1 February 2012

RE: Sydney Super Yacht Marina

Thank you for the opportunity to comment on the Preferred Project Report (PPR) including the revision of Council's original comments forwarded to the Department in February 2011.

GROUND FLOOR PLAN

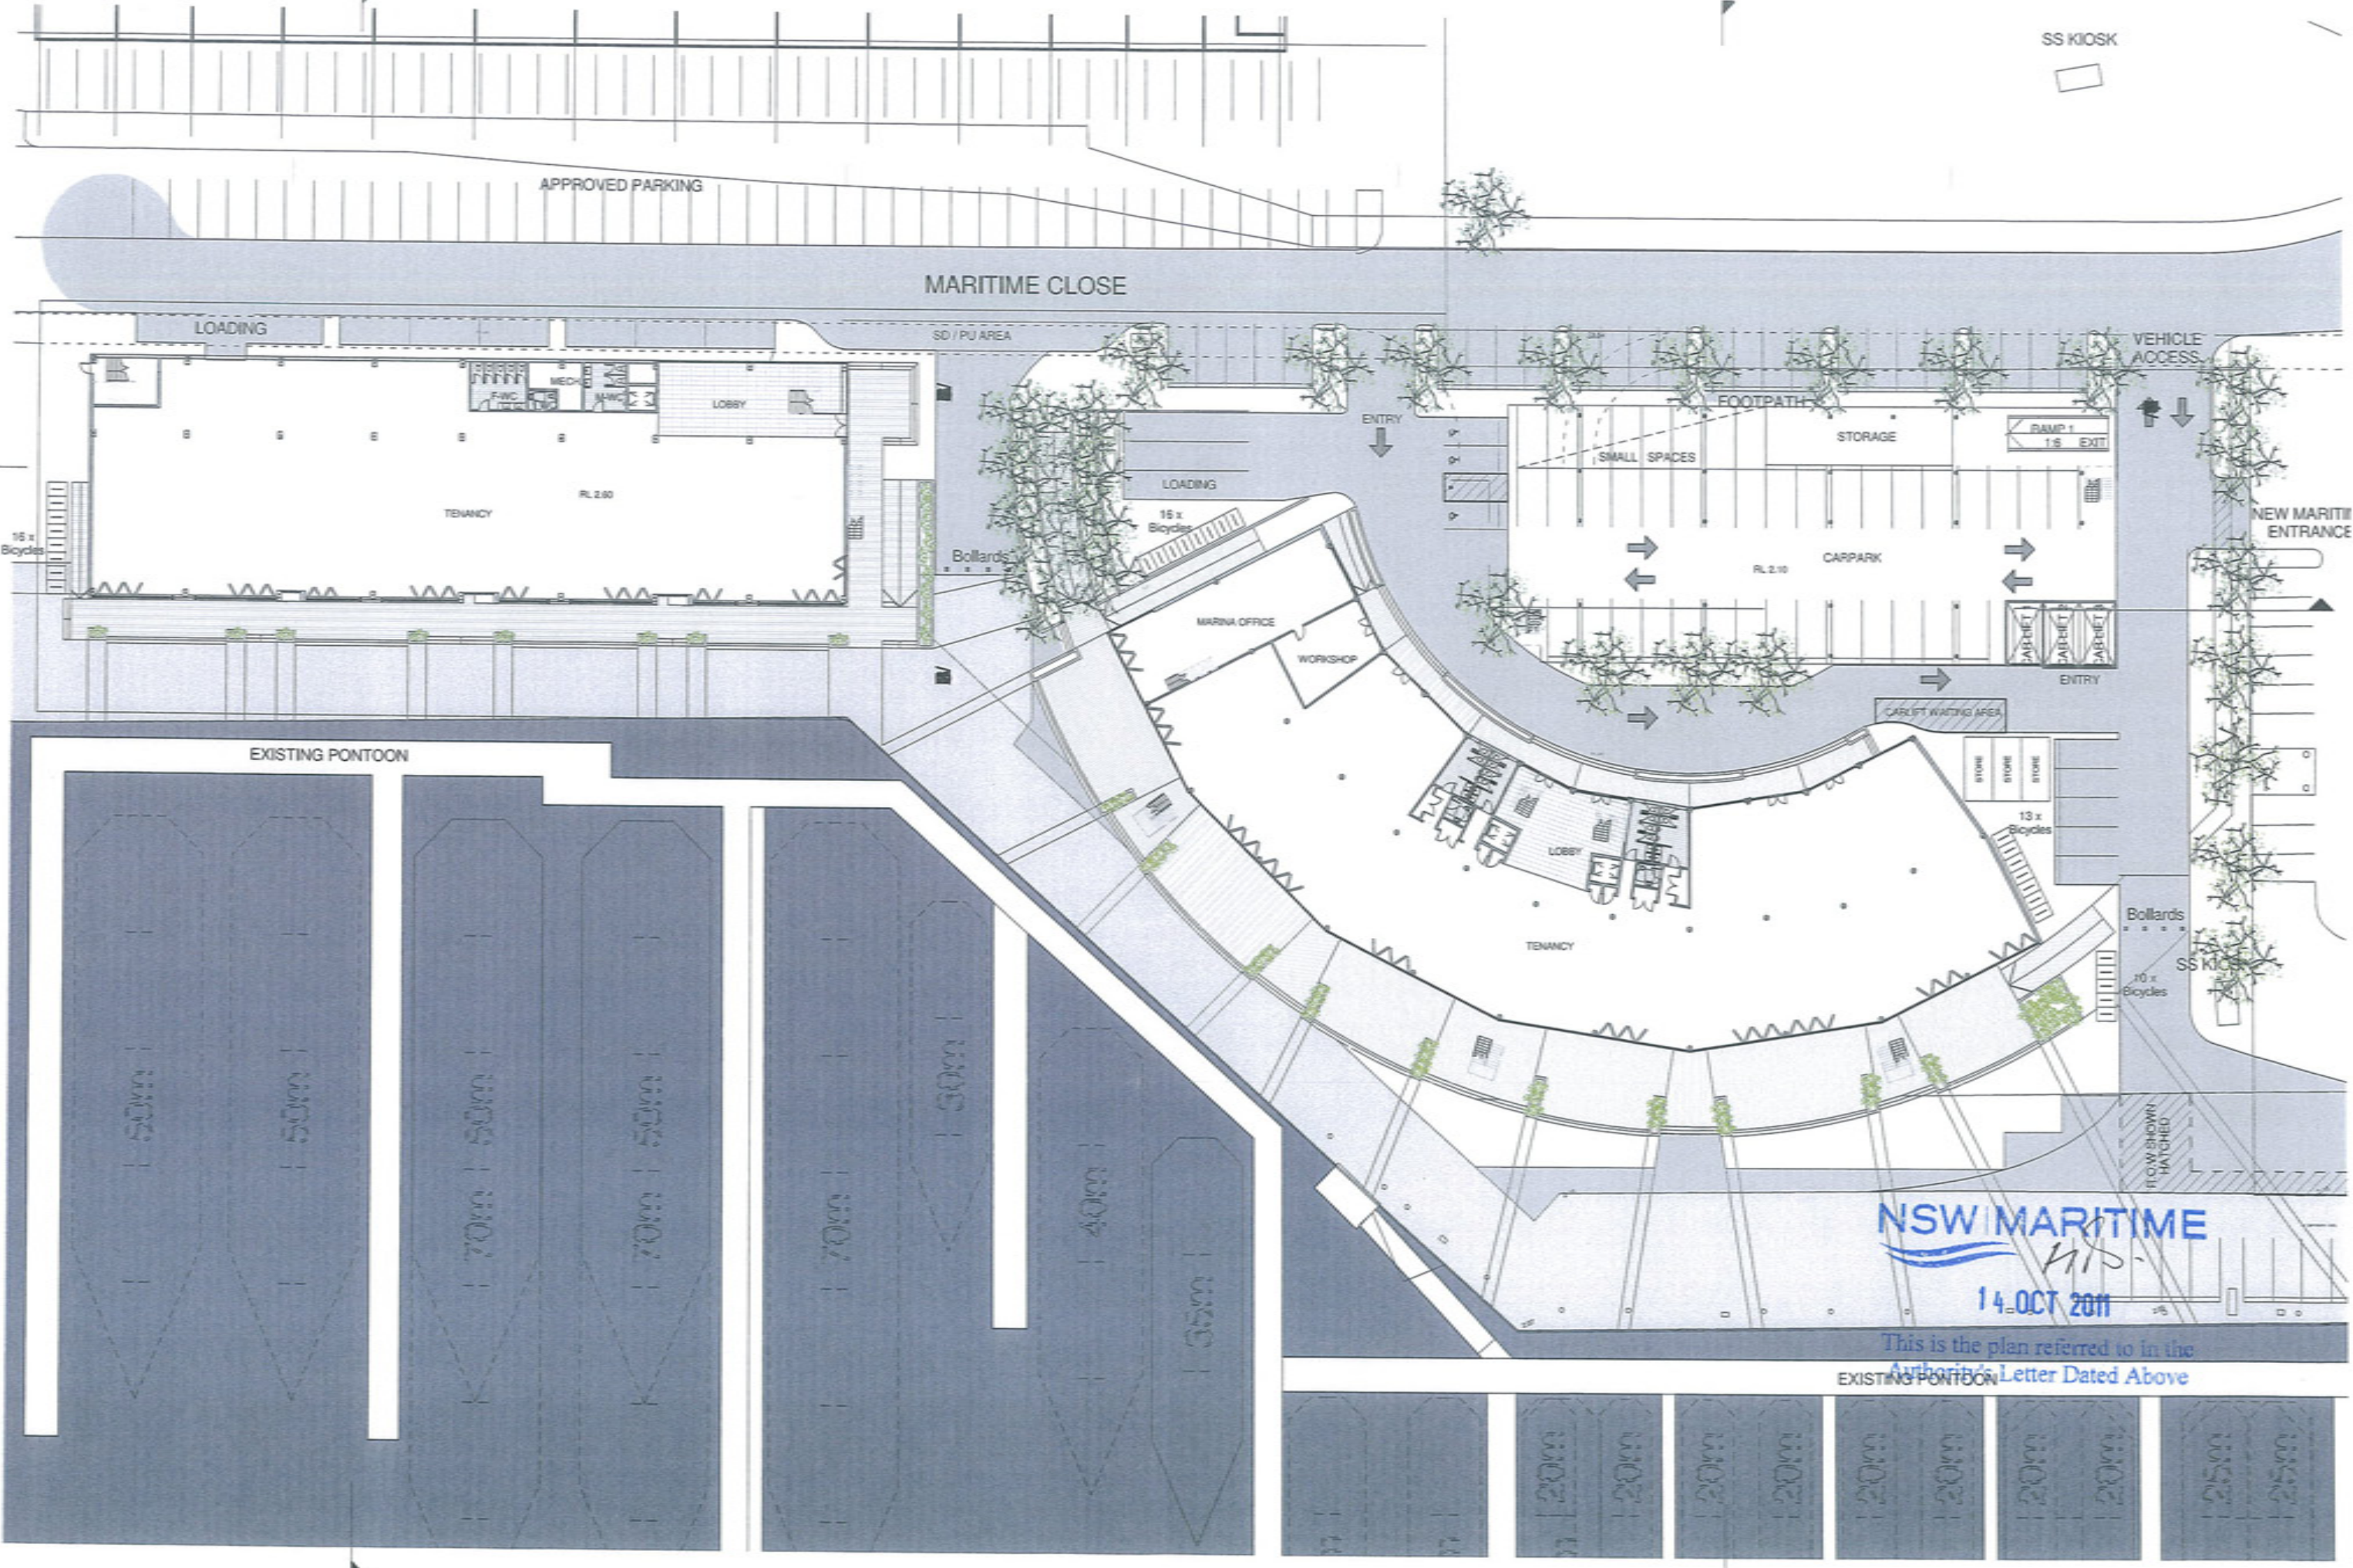
It is also noted that permanent car parking spaces are to be provided adjacent to the waters edge which may restrict the public enjoyment of the location. Alternative arrangements for temporary parking bays for pick up and drop of passengers, materials and for service needs should be investigated.

ELEVATIONS - SHEET 1

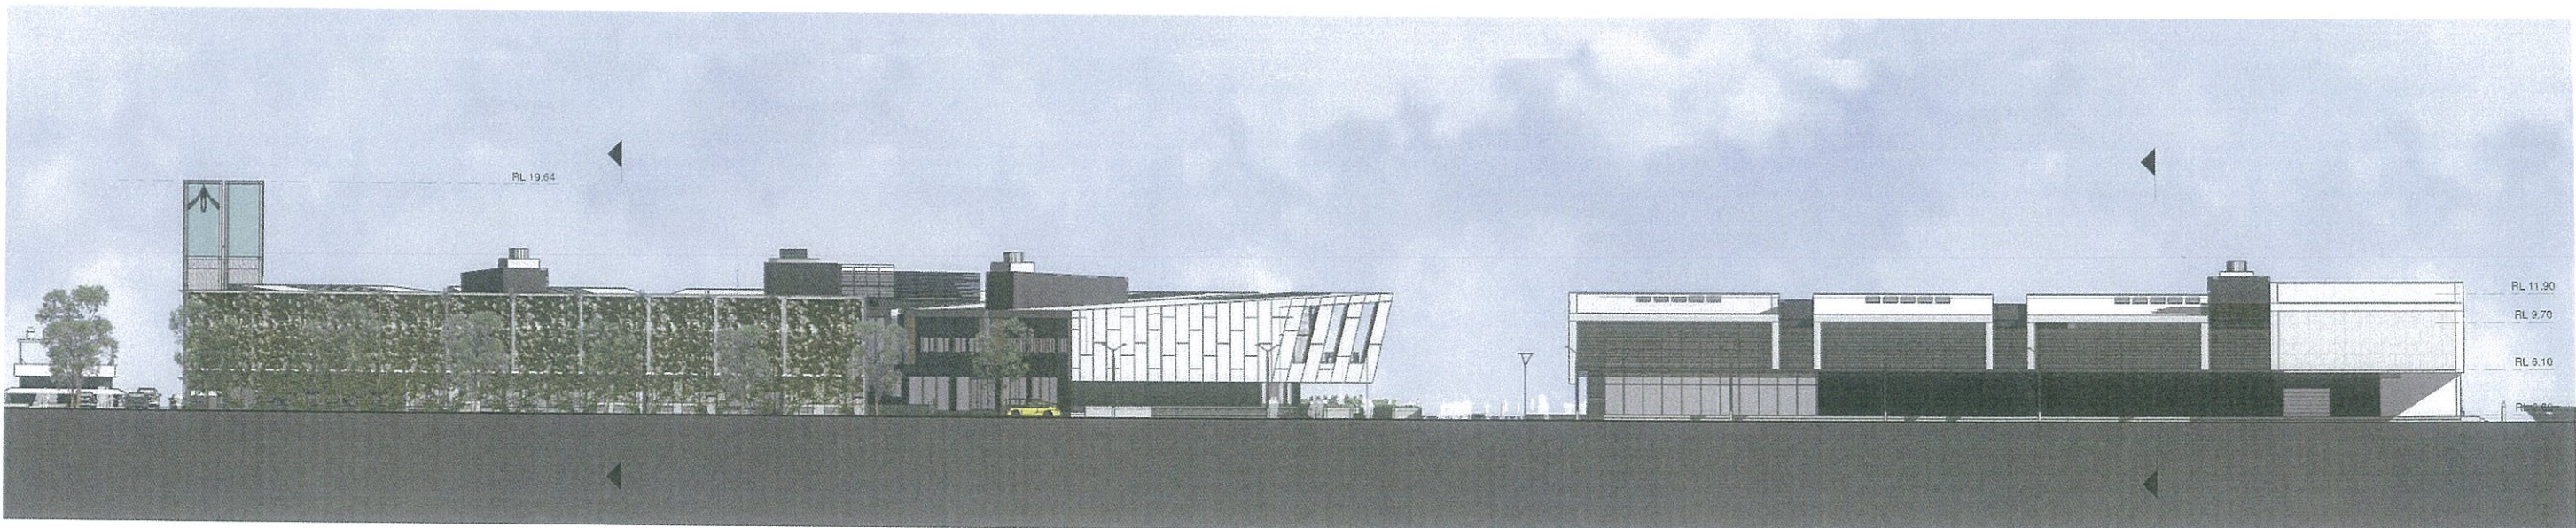
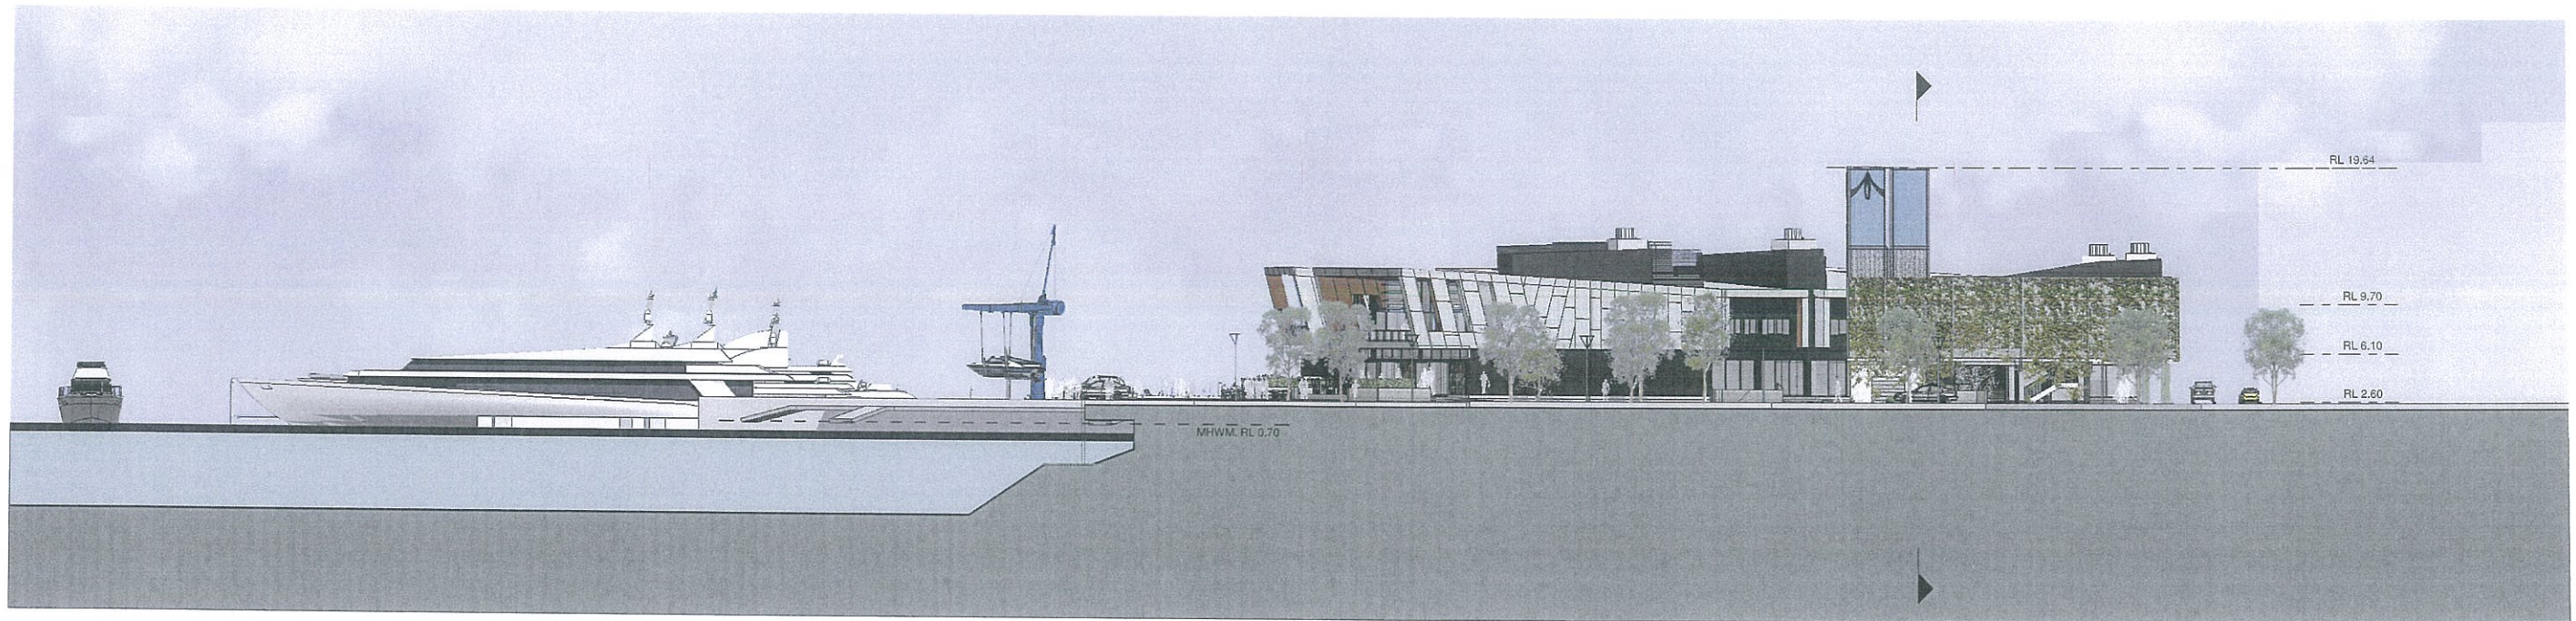
The project description proposes that the lift shaft for the multi level carpark will form a 'visible identification focal point' as justification for what is, essentially a functional requirement of the proposed carpark. Figure 2.4 of the Environmental Assessment document illustrates the south and north elevations and indicates that the lift shaft will be significantly higher than the surrounding buildings. However, no indication is given as to how the lift shaft will make a positive contribution to the establishment of a sense of place, identity and architectural merit nor how it is adequately integrated with the existing or proposed waterfront buildings.

The proponent continues to advocate for a structure which significantly exceeds the height of the focal point that is designated by the Master Plan.
